**From:** Andrew Wood <Andrew.Wood@arun.gov.uk>  
**Sent:** 12 February 2020 09:53  
**To:** Planning.Responses <Planning.Responses@arun.gov.uk>  
**Subject:** FW: A/140/19/NMA FW: Angmering Link Footpath

**Subject:** A/140/19/NMA FW: Angmering Link Footpath

**Subject:** Angmering Link Footpath

Please find attached revised footpath design for the site between Cresswell Park and Quiet Waters, Angmering.

Link Footpath
Horiz. 1:100 Vert. 1:50

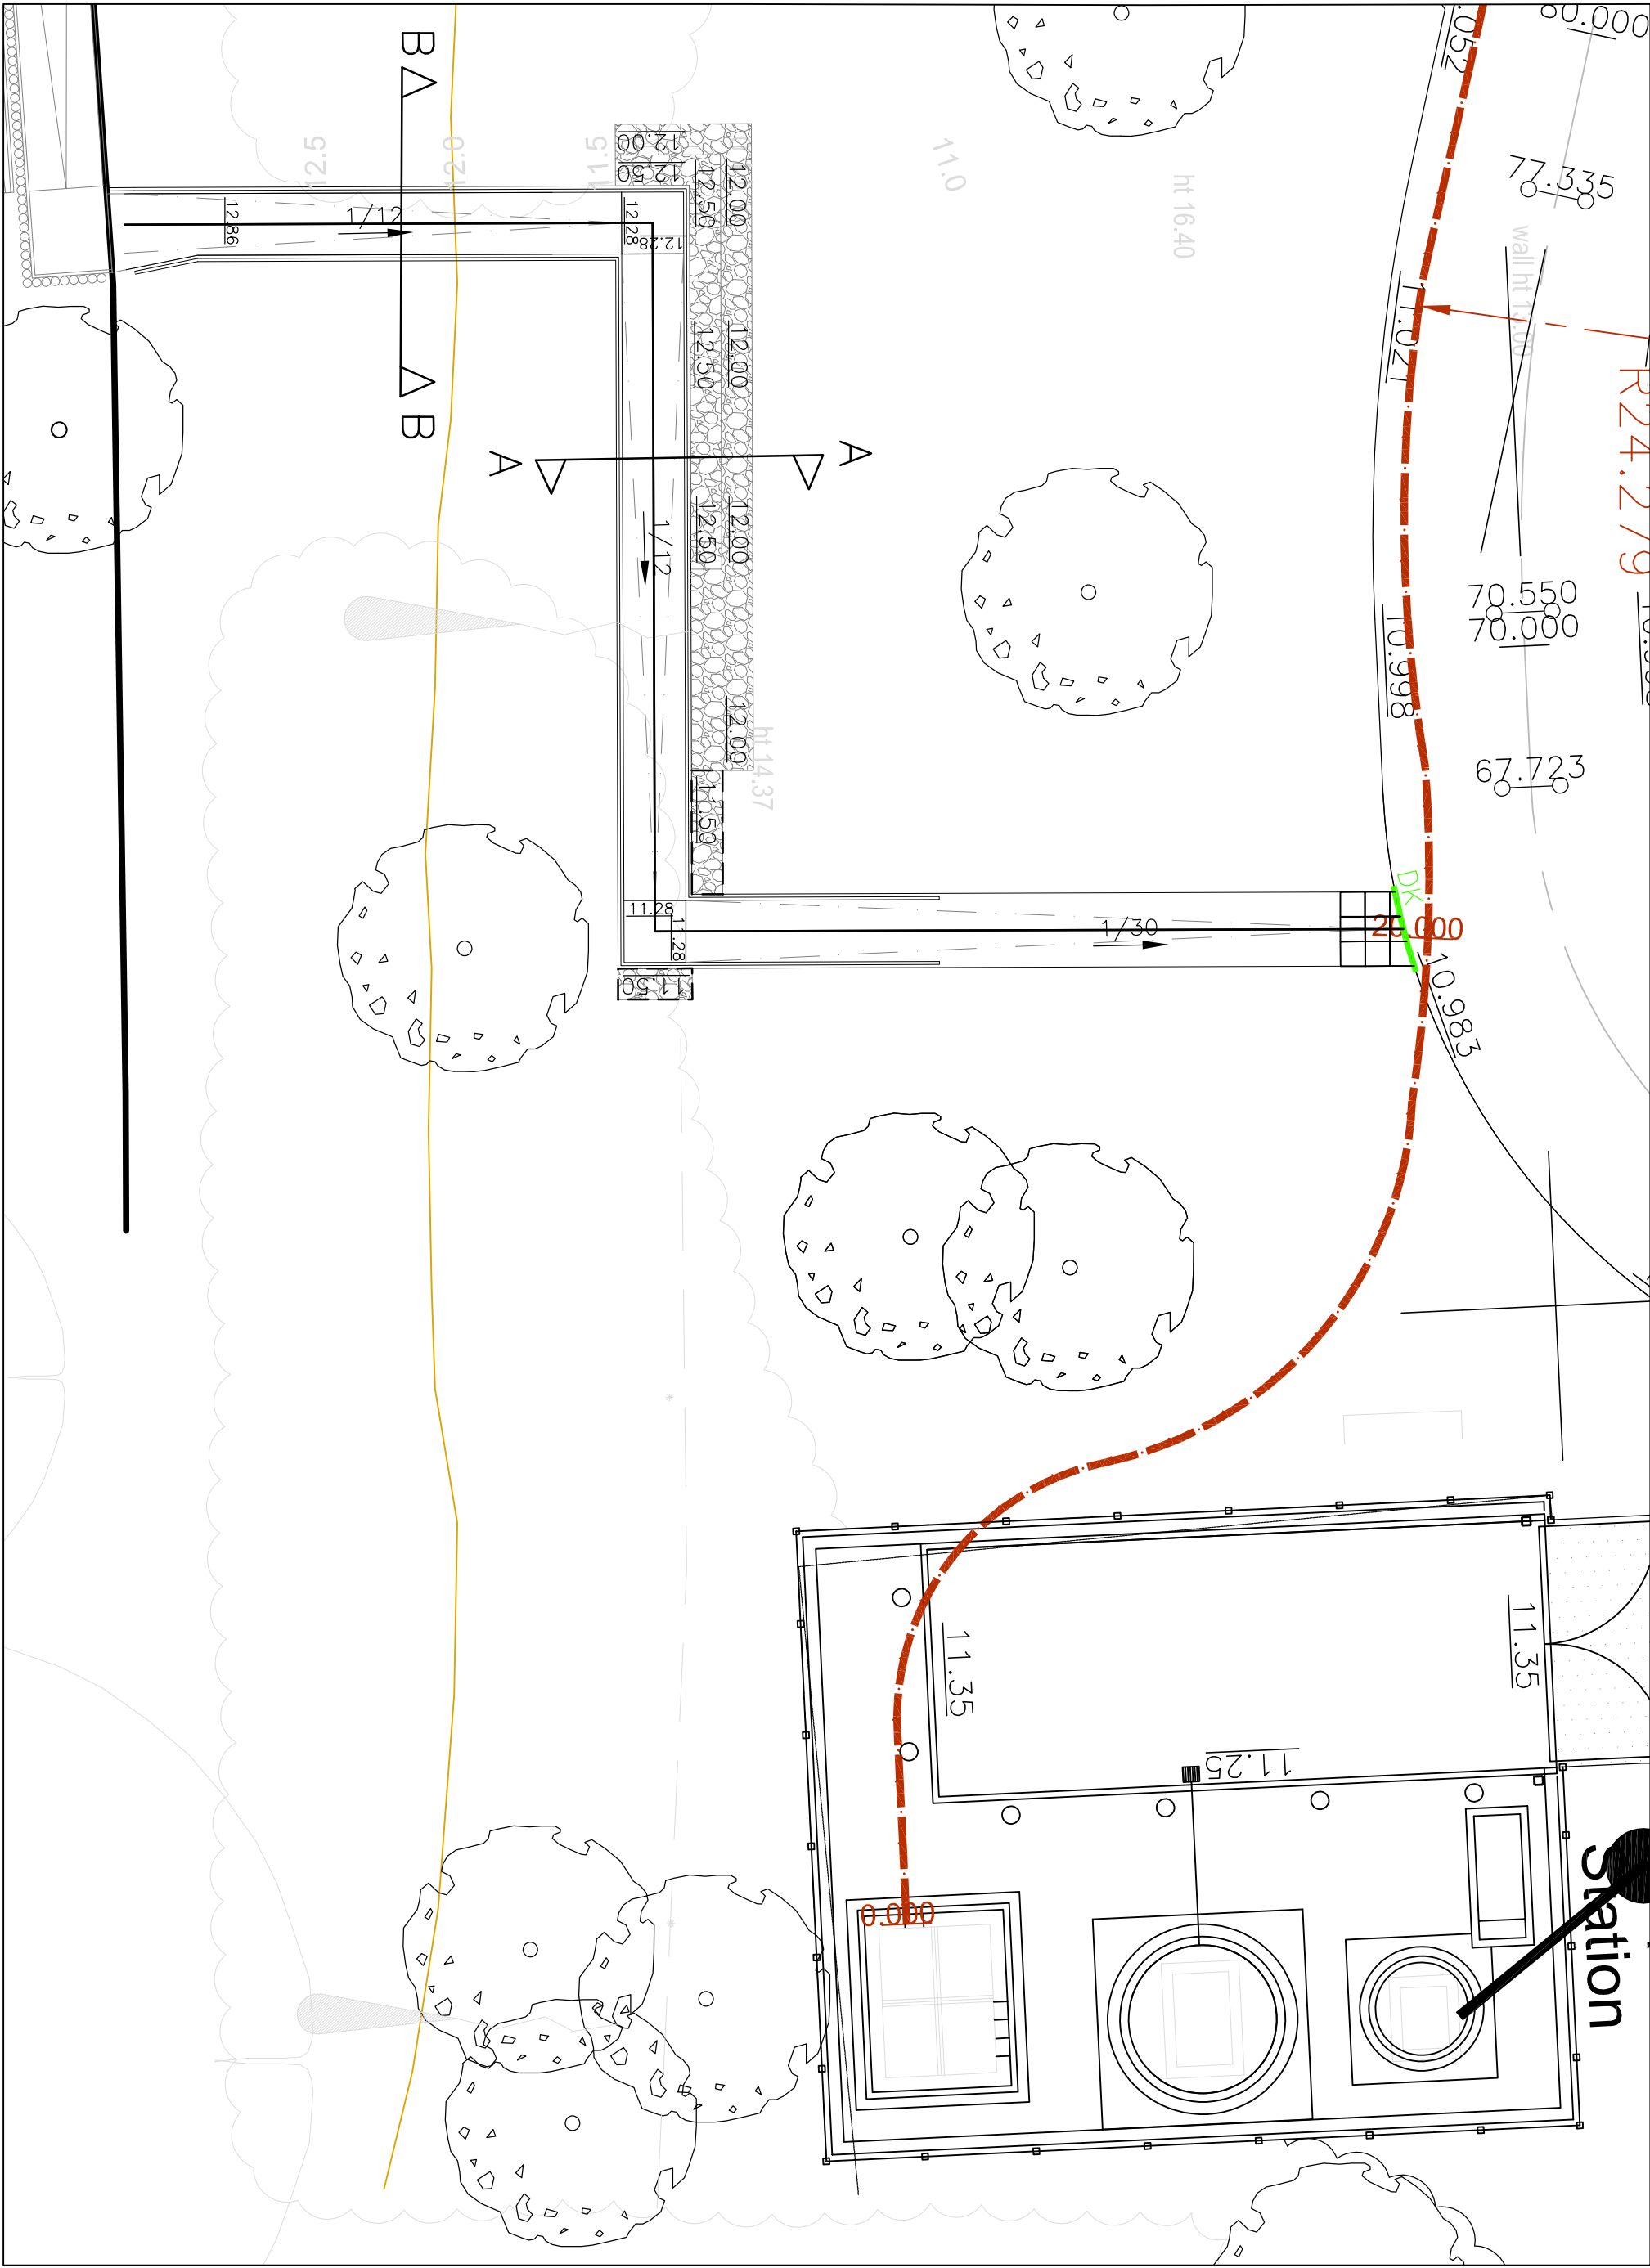
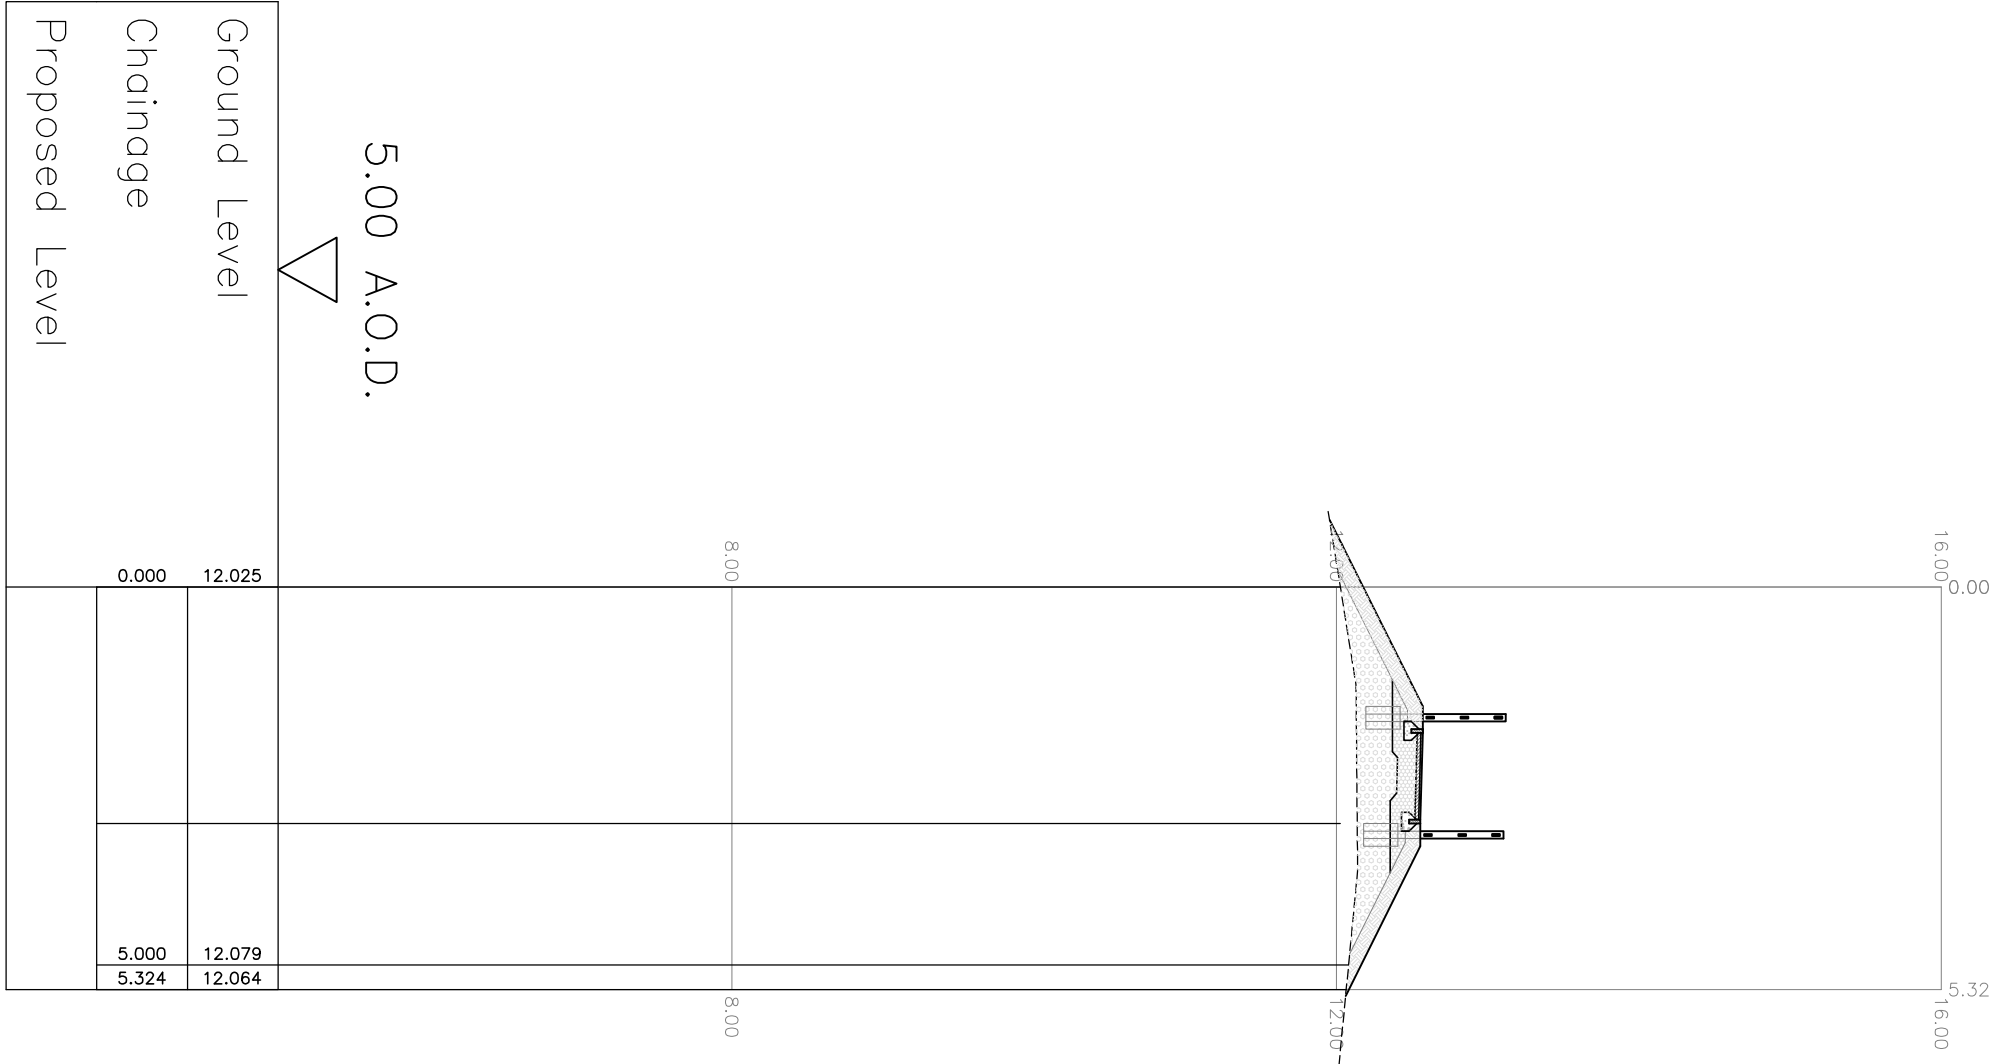
Following your email of Thu 06/02/2020 15:45 Please see amended plans for footpath link.

Is this acceptable?

Andrew,  
Plan is the minimum acceptable width as such no objection is raised to the NMA.
